Rosefield Solar Farm (EN010158)

**Buckinghamshire Council's Updated Principal Areas of
Disagreement**

Buckinghamshire Council

June 2026

Drawing number	Revision number	Drawing title	Scale
4.1	01	Stage 1 Zonal Masterplan	1:25,000 @ A3
4.2	01	Stage 2 Zonal Masterplan	1:30,000 @ A3
4.3	01	Stage 2 Zonal Masterplan Scenario 1	1:10,000 @ A3
4.4	01	Stage 2 Zonal Masterplan Scenario 2	1:10,000 @ A3

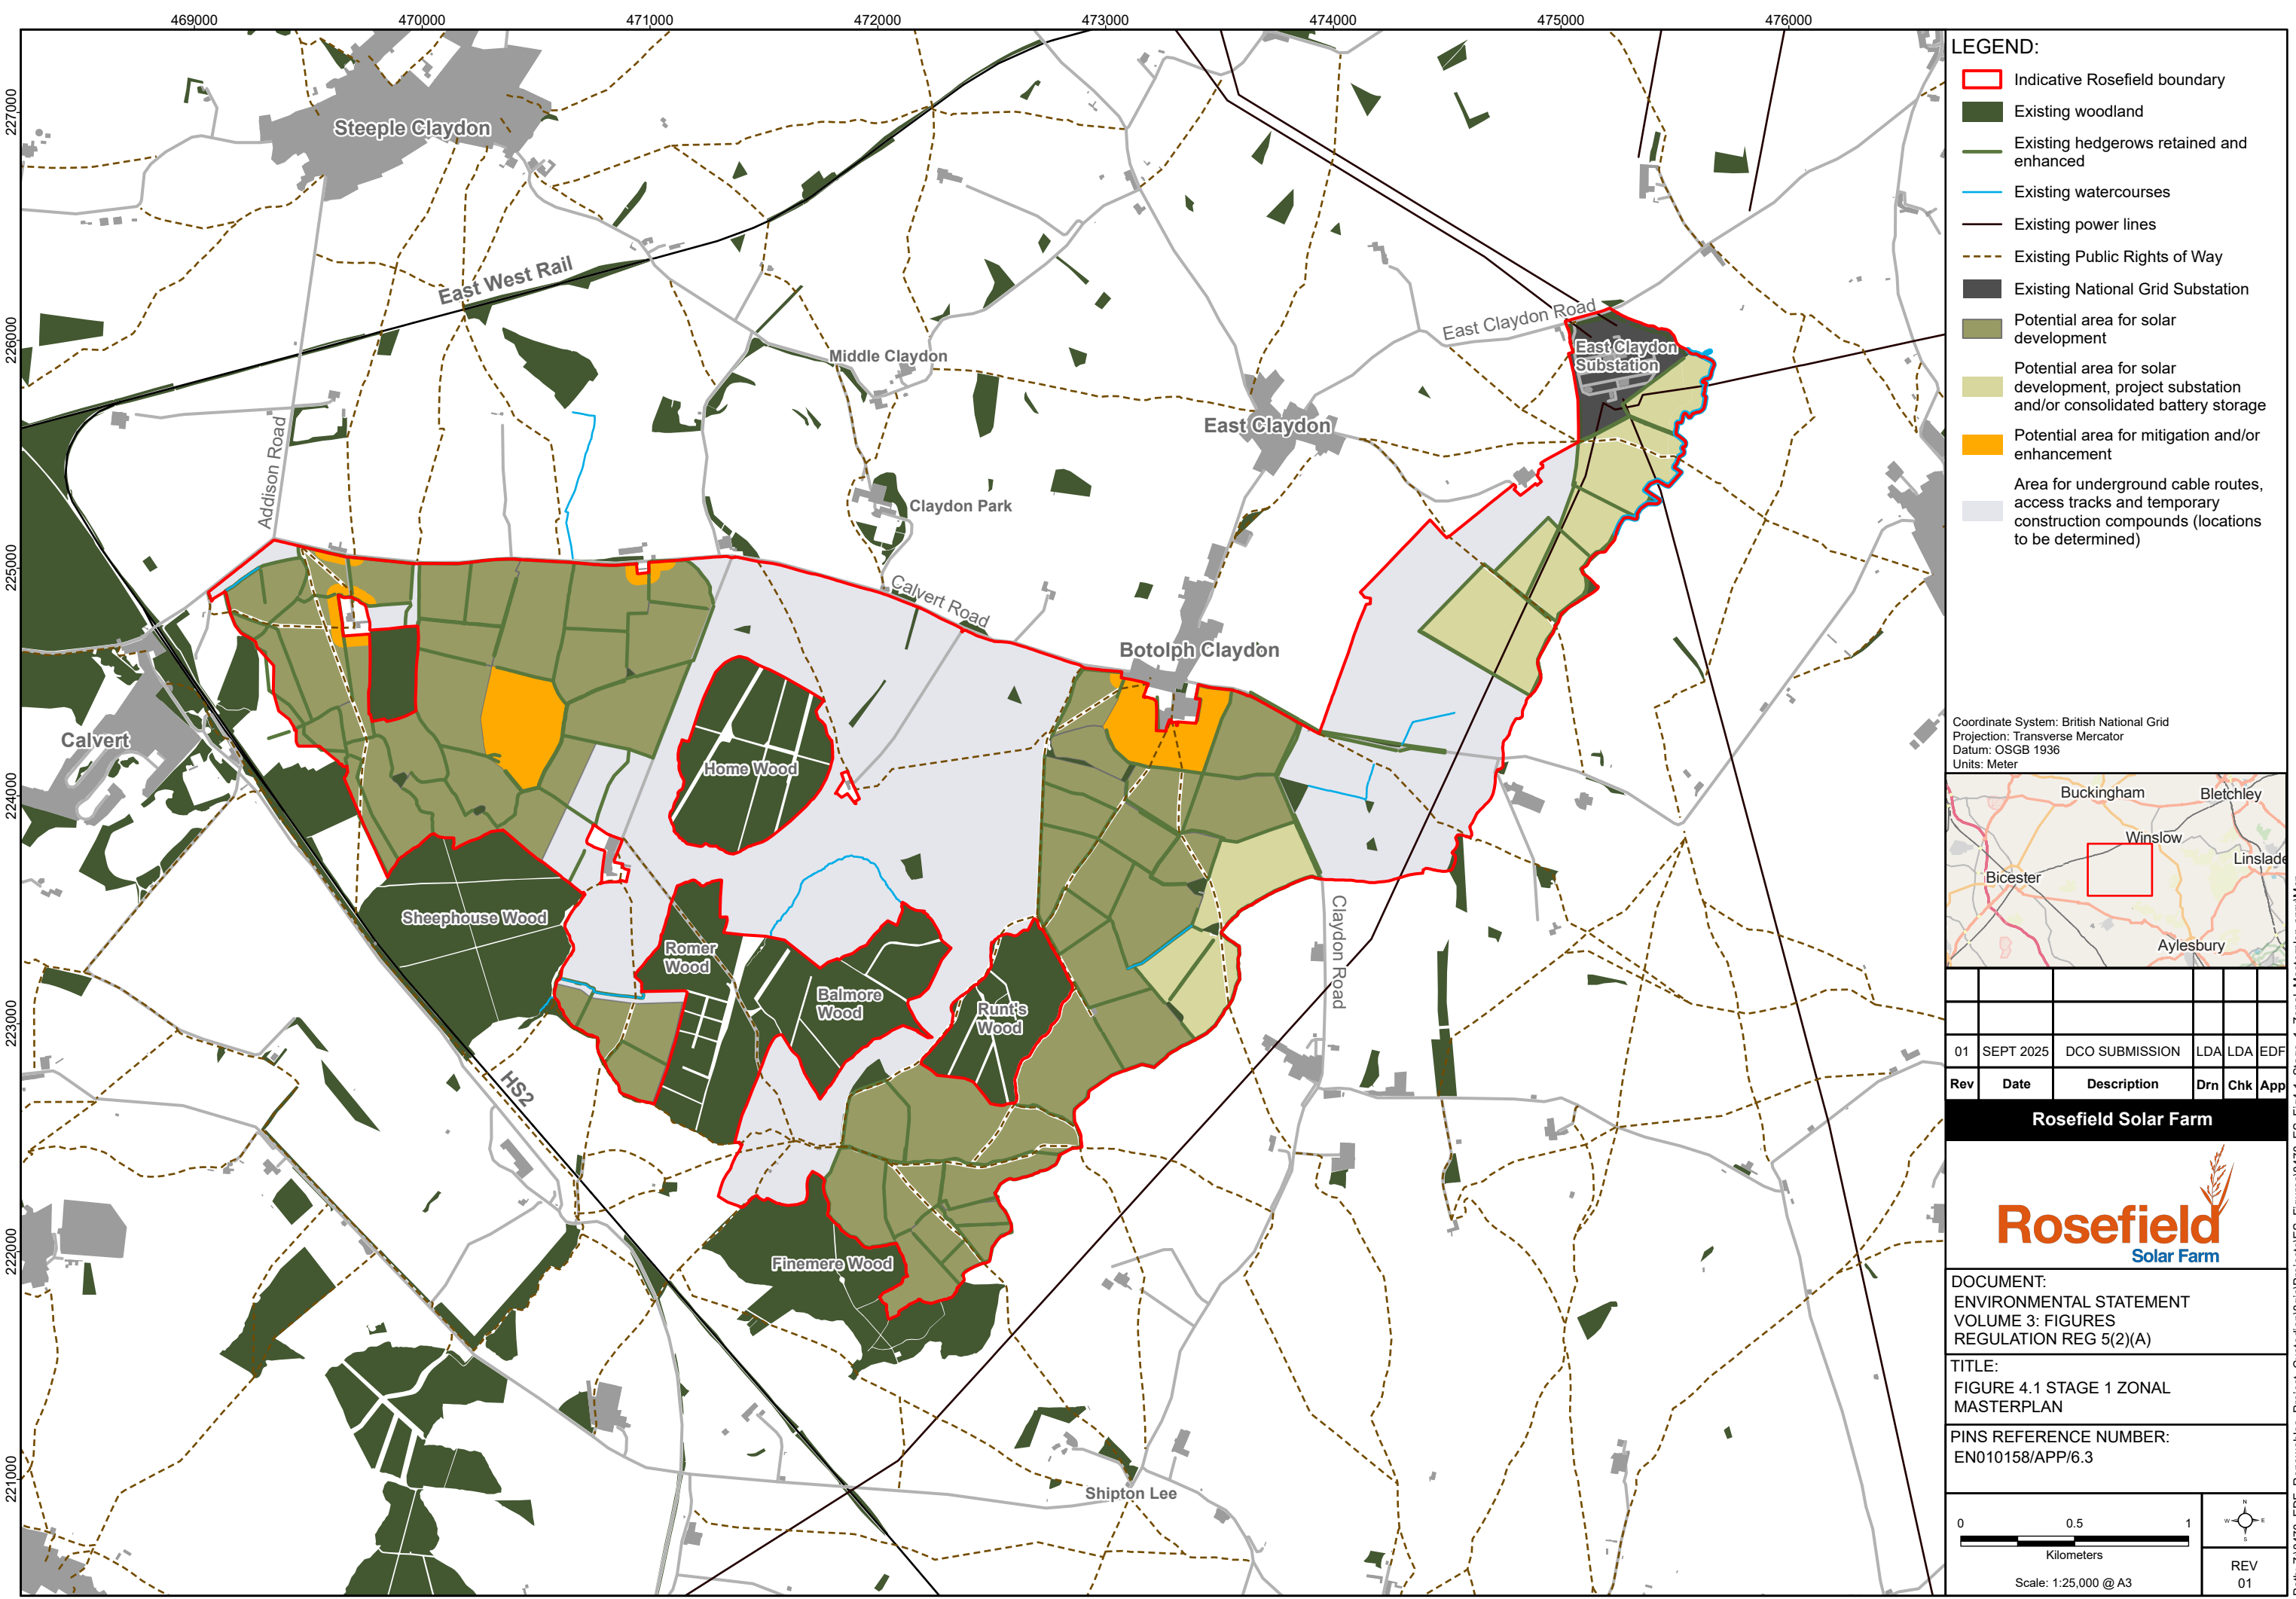
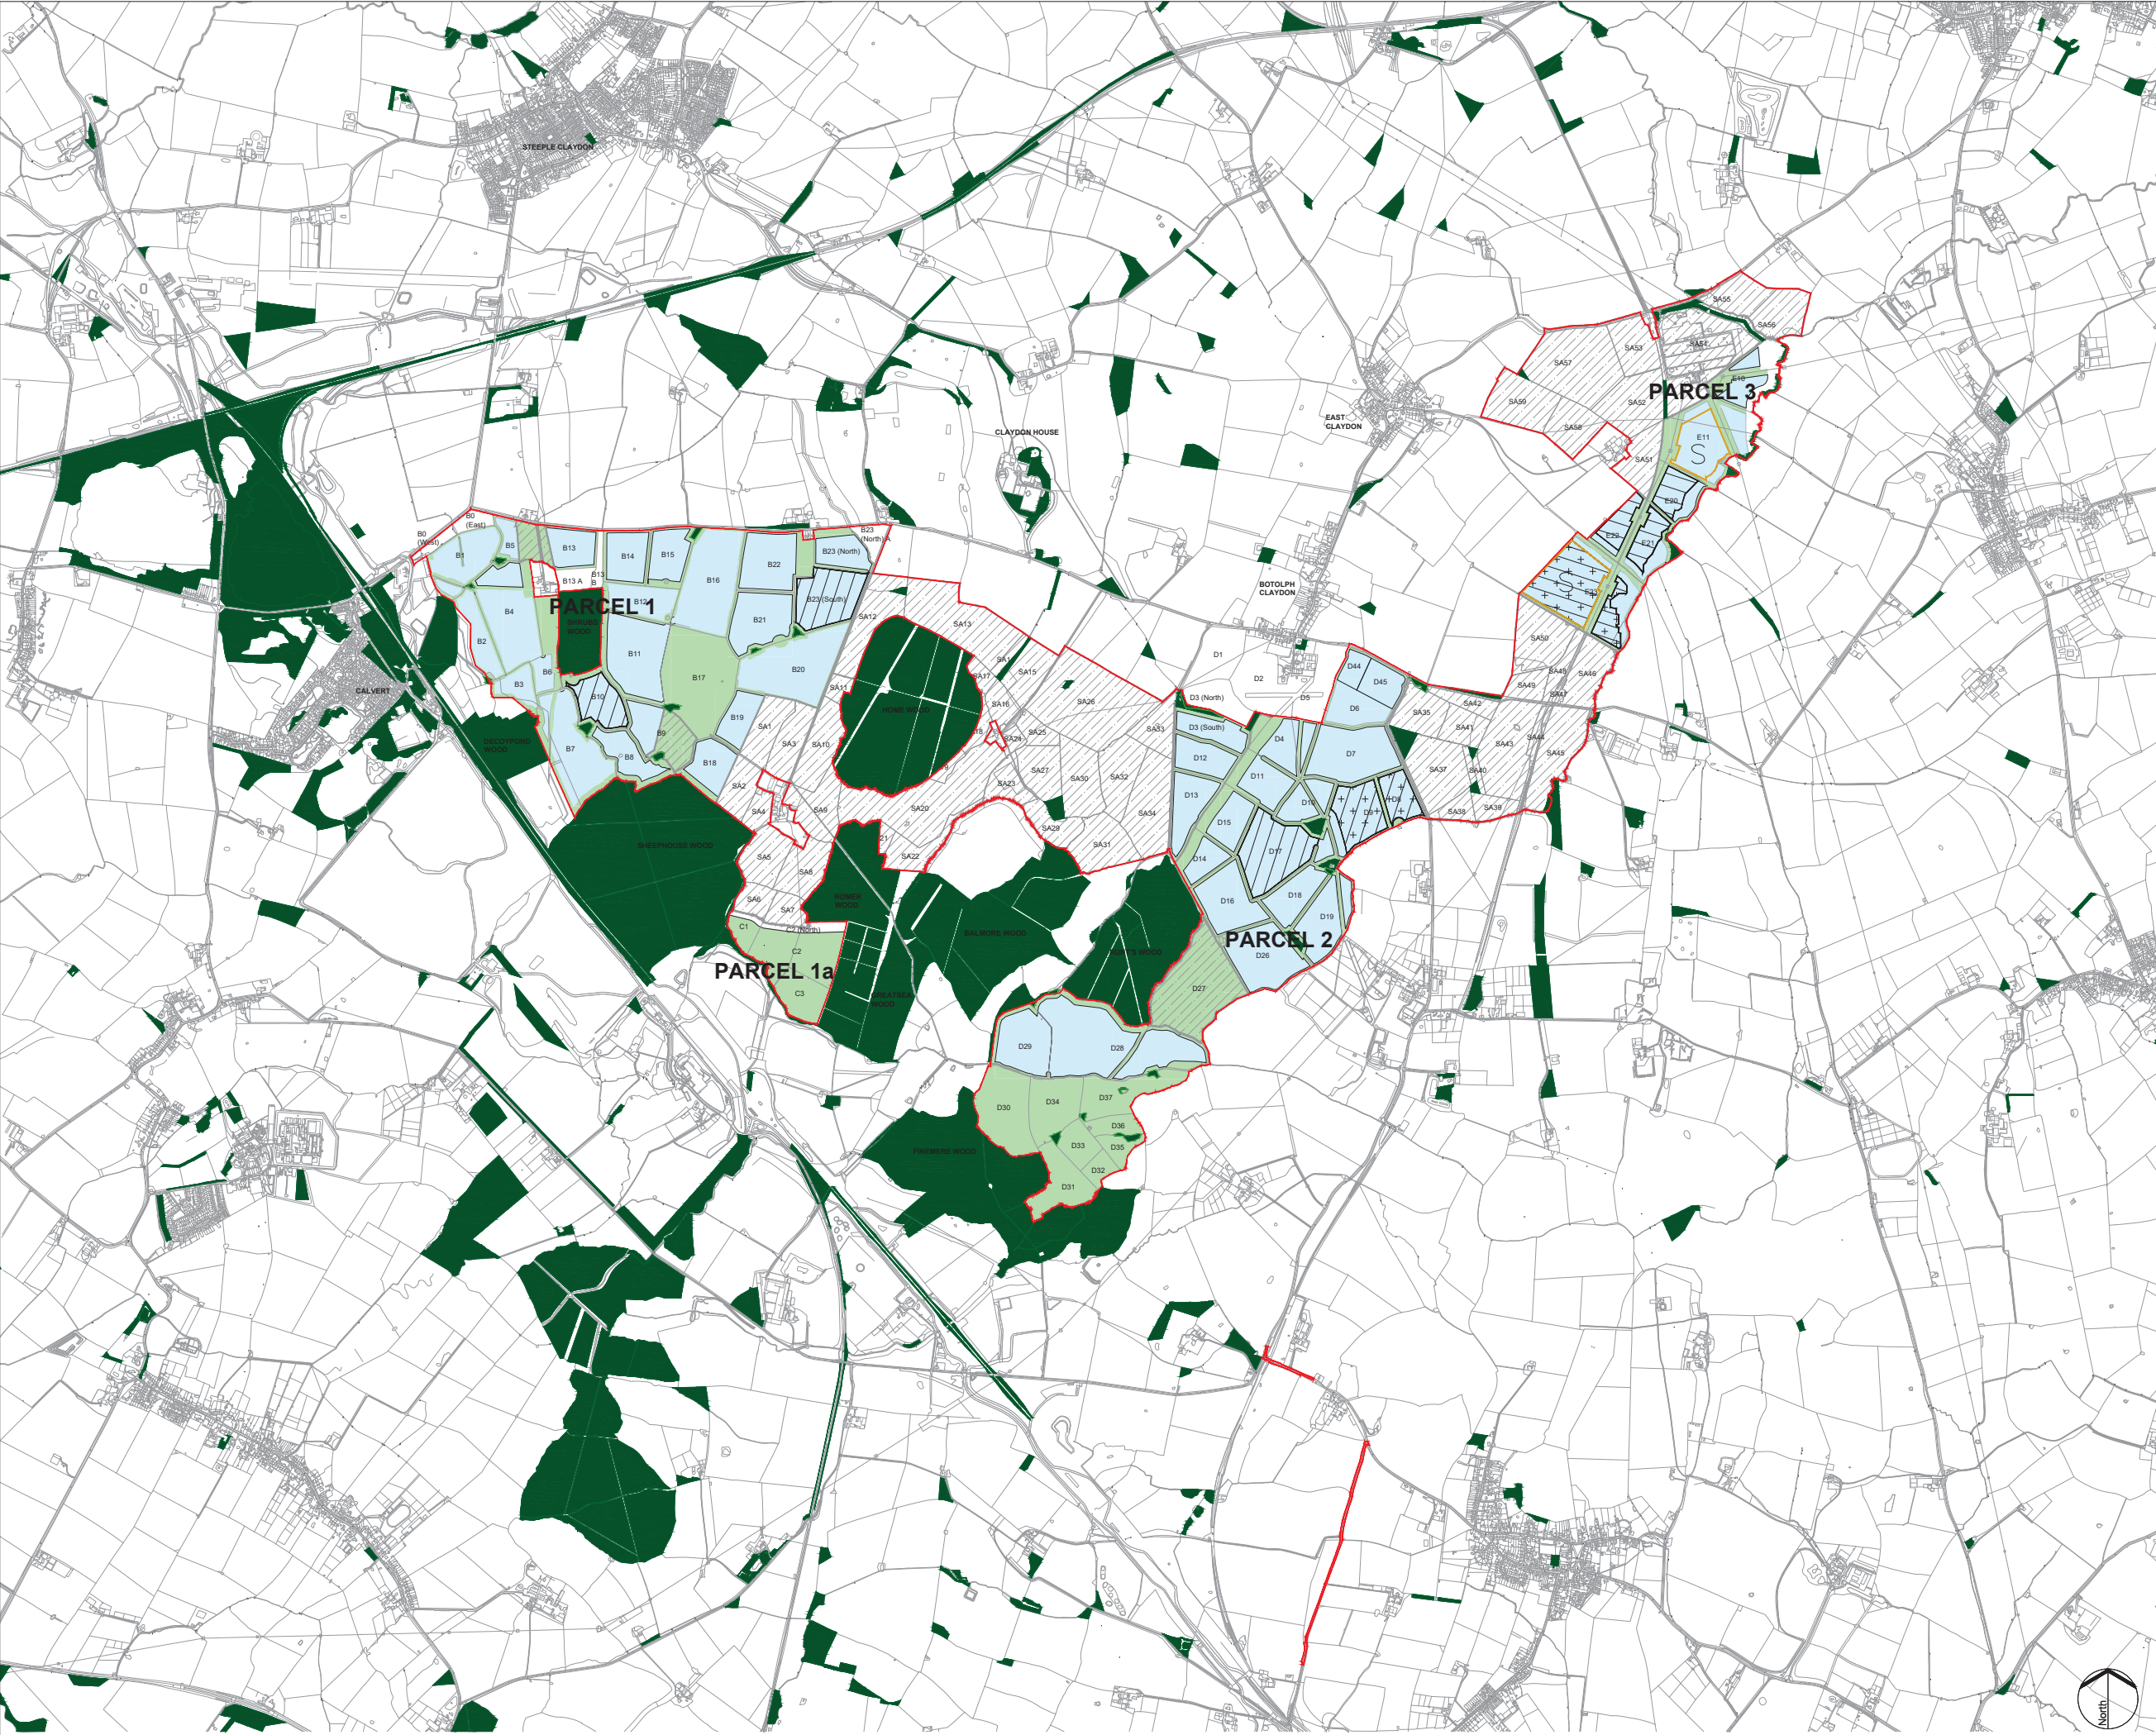
Area of Concern	Explanation	Remedy Measures	Likelihood of Resolution
<p>Site Selection</p>	<p>Site selection process appears to have been driven primarily by single landowner availability, not by a constraints-led or environmentally proportionate assessment.</p> <p>Lack of evidence that other land parcels within the 10km search area were identified, evaluated or discounted on environmental, landscape or planning grounds.</p> <p>No clear demonstration that the Applicant considered alternative locations for the BESS, including less visually sensitive parcels.</p> <p>Insufficient assessment of the undulating landform, which intensifies visual prominence from PRowS and settlements.</p> <p>Failure to consider whether flatter or more enclosed areas both within and outside the landholding could reduce landscape, heritage or ecological harm.</p> <p>Incomplete exploration of opportunities to co-locate the BESS with existing or consented energy infrastructure, including the</p>	<p>Provide an alternatives assessment, demonstrating a constraints-led approach to site selection across the full 10km search area.</p> <p>Reassess all available land parcels (inside and outside the willing landowner area) against ecological, landscape, heritage and PRowS sensitivity.</p> <p>Relocate the BESS away from fields D8/D9 to a less visually elevated and less heritage-sensitive parcel with better containment.</p> <p>Demonstrate that the chosen layout represents the least-harm option within the Order Limits, evidenced through sequential design testing.</p> <p>Provide an options appraisal for co-location with existing or consented infrastructure, especially the National Grid substation and adjacent consented BESS.</p> <p>Include detailed topographical and ZTV-led analysis showing how alternative siting could reduce visual harm.</p>	<p>Low</p>

Area of Concern	Explanation	Remedy Measures	Likelihood of Resolution
	<p>National Grid substation and consented BESS sites.</p> <p>Insufficient justification for selecting fields D8/D9 for the BESS despite elevated, visually exposed, and heritage-sensitive context.</p> <p>No transparent assessment showing whether alternative layouts within the Order Limits could avoid highest-sensitivity landscape, ecological and heritage receptors.</p> <p>Issues related to removal of panels from PV for ecological and landscape reasons are addressed in the appropriate section below.</p>	<p>Revisit design to avoid siting infrastructure in parcels within the highest ecological sensitivity, including areas forming critical habitat connectivity.</p> <p>Supply full justification for why alternative land parcels could not be used, aligned with EN-1 and EN-3 requirements for proportional alternatives assessment.</p>
